Application: SSI 7485

I write regarding the proposed modification to M4-M5 Link, Mod 2 The Crescent overpass and changes to pedestrian infrastructure in North Annandale, Rozelle and Rozelle Bay Foreshore area.

Figure 4-2 Pedestrian and cyclist bridge infrastructure options

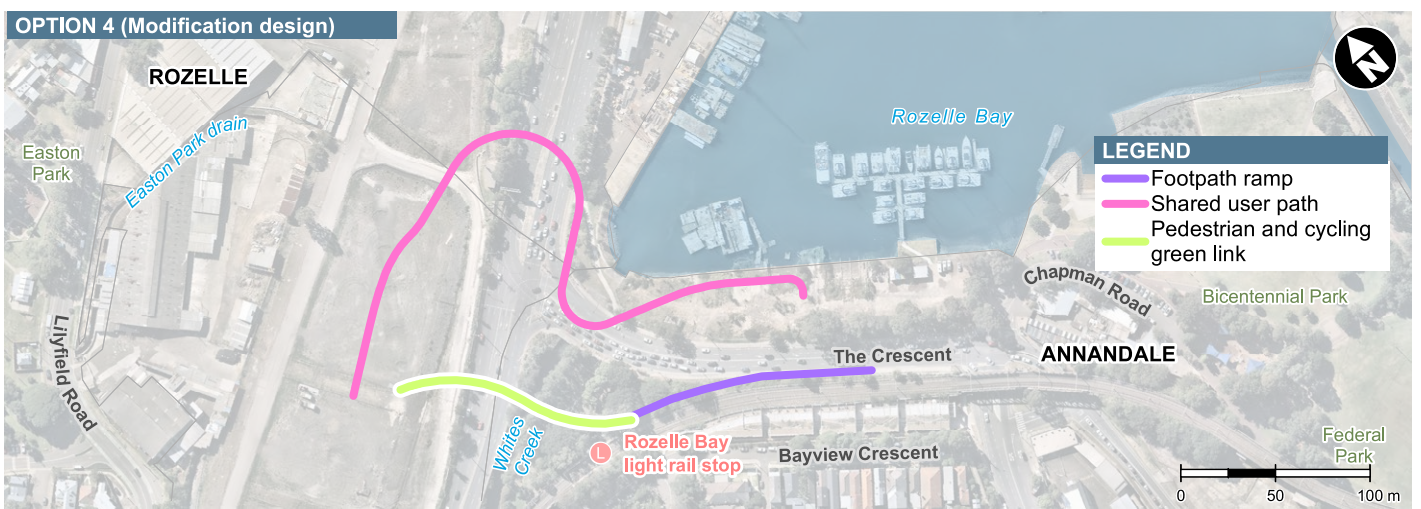
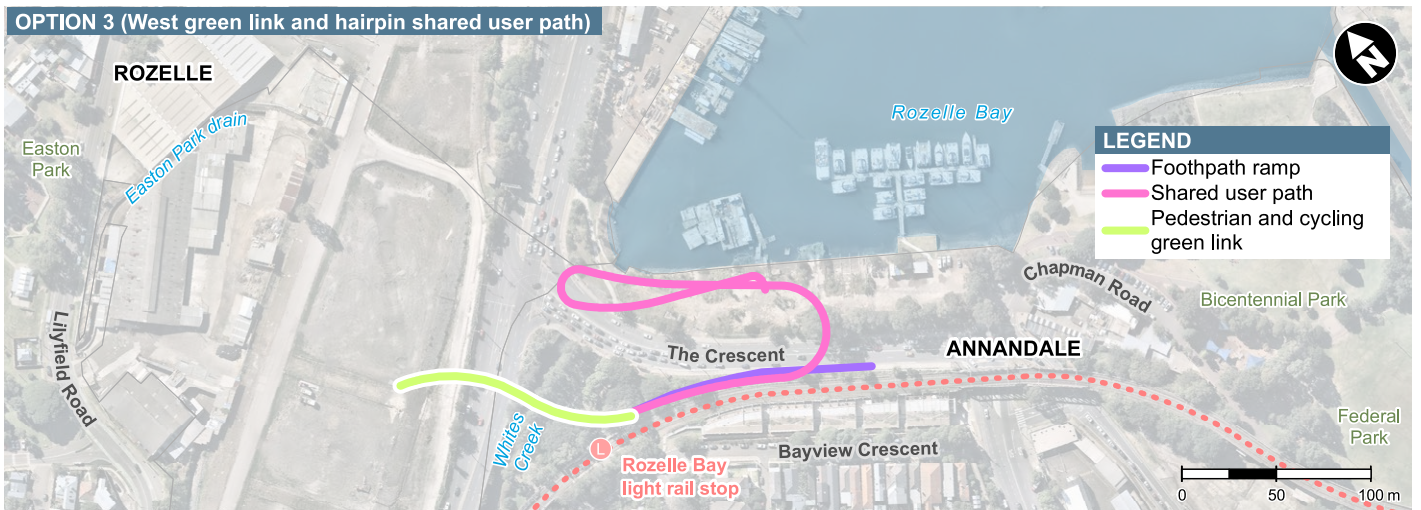
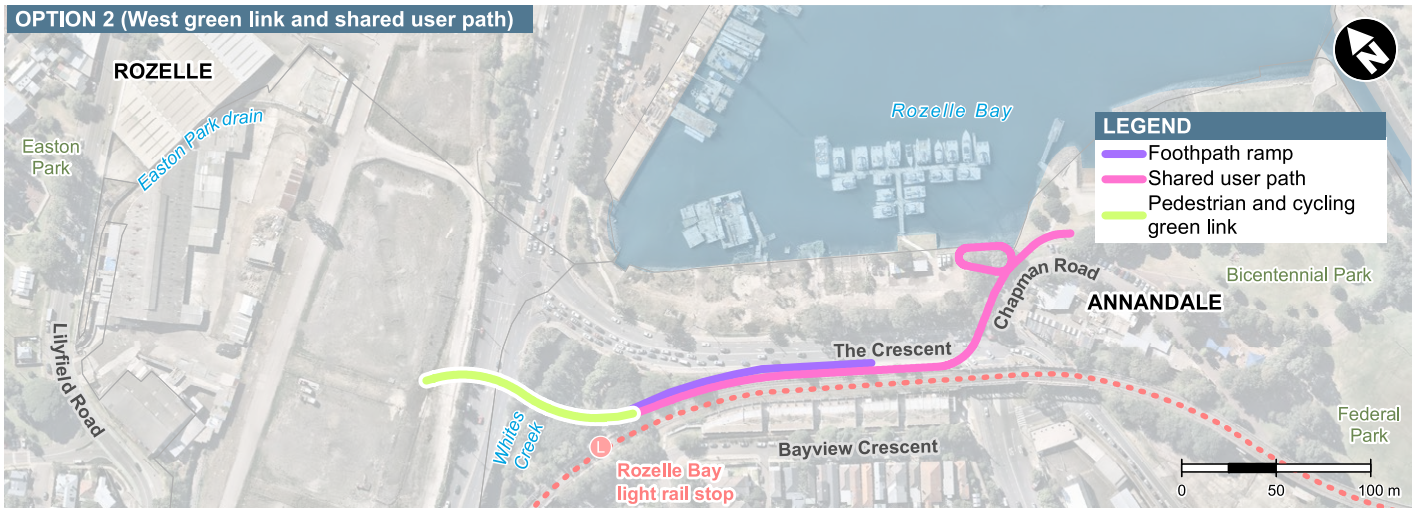
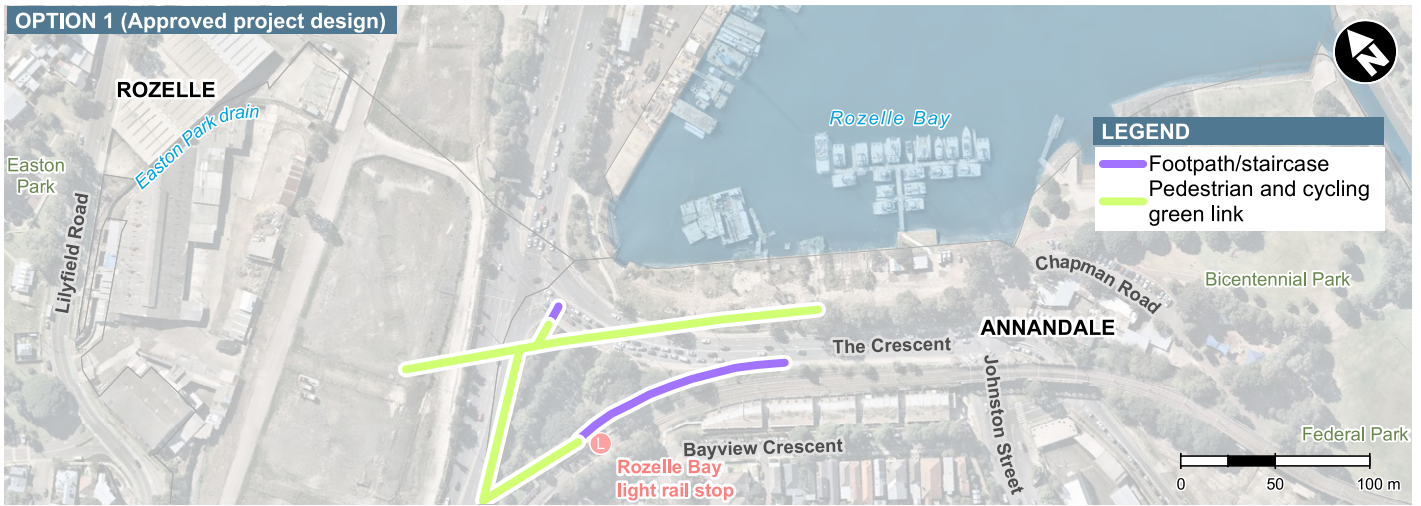
I request RMS work with the community to explore alternate design options to the proposed new car overpass design and the changed pedestrian and cyclist links. I am seeking the reinstatement of the safe, direct access from the approved EIS GreenLink to create a continuous green open space connection from the Rozelle Rail yards and Annandale to the foreshore. The GreenLink was more than just a walk way - it put people central to the design, maximising safety, and providing much needed accessible open space for the community now and into the future Bays Precinct design.

- The significantly reduced safety and increased risk for pedestrians and cyclists with removed access over The Crescent to Bicentennial Park and the increased traffic along Johnson Street.
- Being required to cross five sets of pedestrian lights at The Crescent as my option to reach the foreshore from Annandale or from Rozelle Bay light rail stop.
- Removal of direct active links to the foreshore, cutting the community off from the area and the proposed revitalisation of the entire Bays Precinct, including linking the Light Rail and Bus stops to a Ferry wharf and Metro station.
- Urban and landscape design that is being built before a finalised Masterplan for the area.
- Traffic changes that limit movements around the suburb and create further congestion in the local streets of Annandale, Forest Lodge, Glebe, Lilyfield and Rozelle with no planning to deal with these.

- ✓ • Reinststate the GreenLink connecting communities and green open space from Rozelle to Bicentennial Park
- ✓ • Relocate and design pedestrian and cyclist connections that are continuous, safe and direct.
- ✓ • Design the modification infrastructure and active links in response to the character of the suburbs, the location of the foreshore and it's potential future development.
- ✓ • Provide pedestrian and cyclist paths that maximise people safety and do not force them onto busier streets, unsafe concrete plazas and caged walkways.
- ✓ • Integrate active and direct connections to all active transport – including the future Metro West and Foreshore Ferry Wharf

Figure 4-3 The Crescent, Johnston Street, Chapman Road intersection options

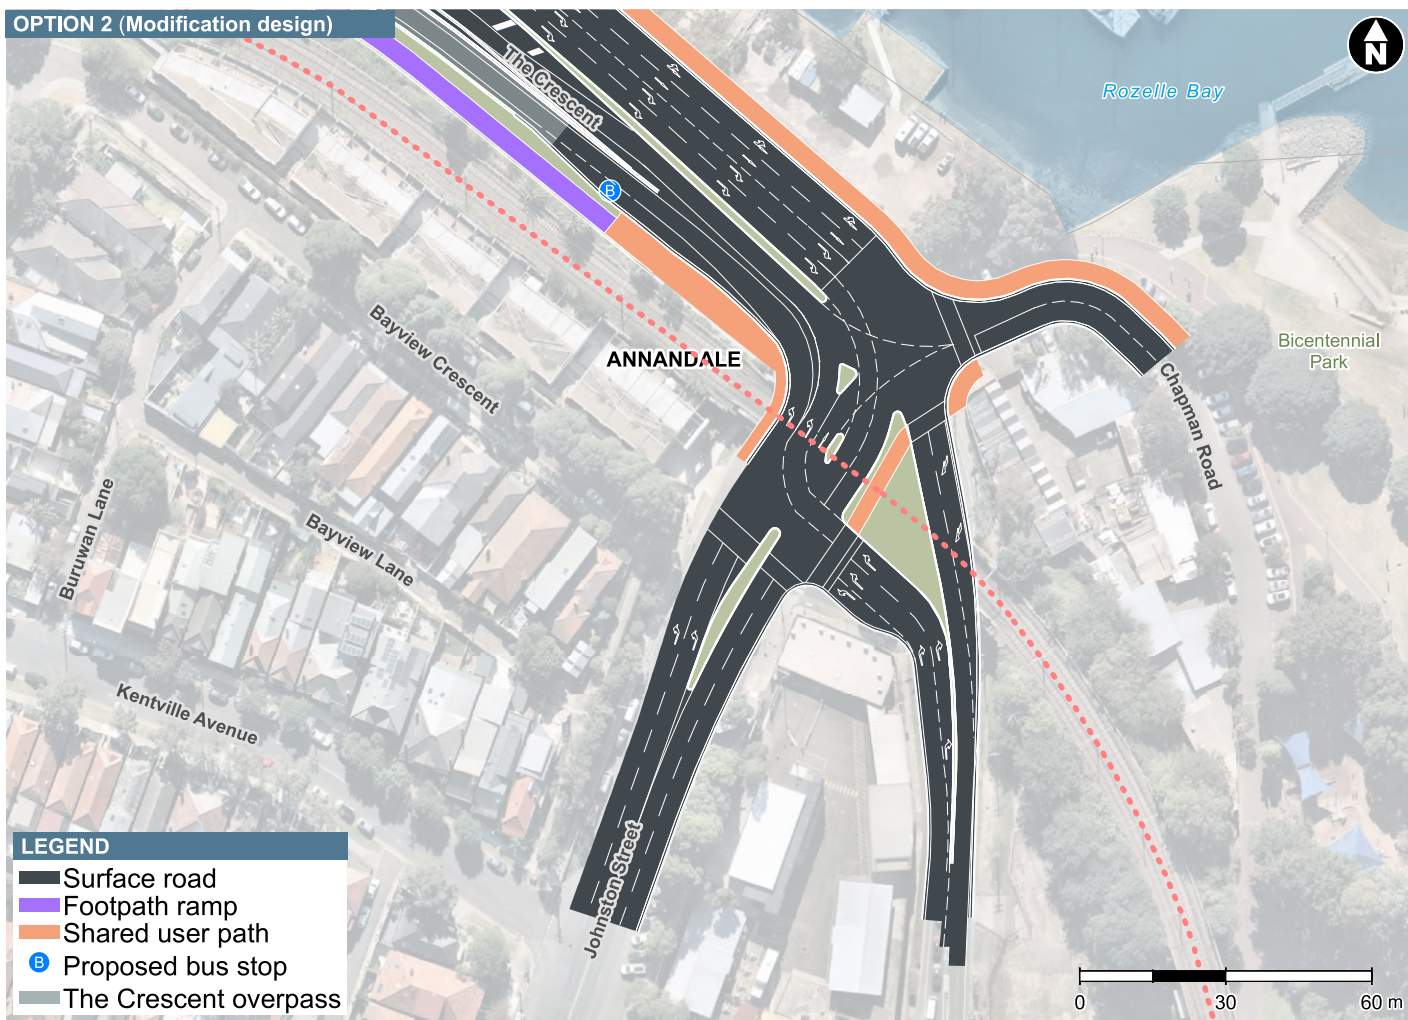
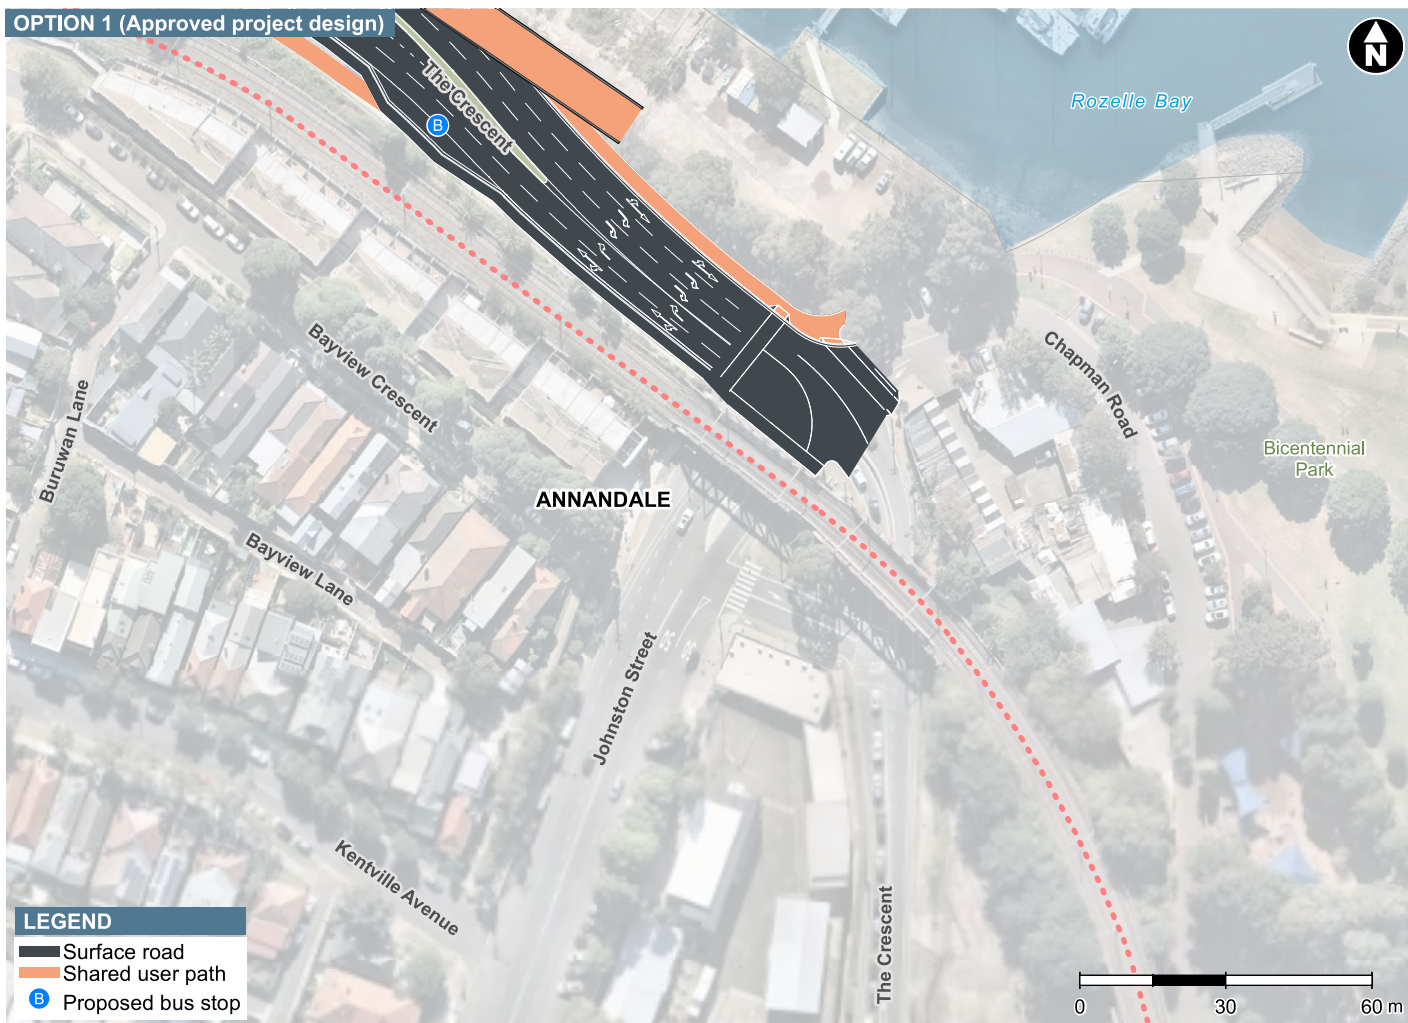
• loss of right hand turn from Johnson St to Crescent esp for locals
• Reduction of turning lanes @ from Crescent to City West link / bridge
• Backward design of (L) hand turn from Cresto to City West now involves crossing to Right hand of proposed overpass entry.
• Unnecessary loss of vegetation before planning proceeds / settled.
• In general a much poorer quality of community / foreshore access.
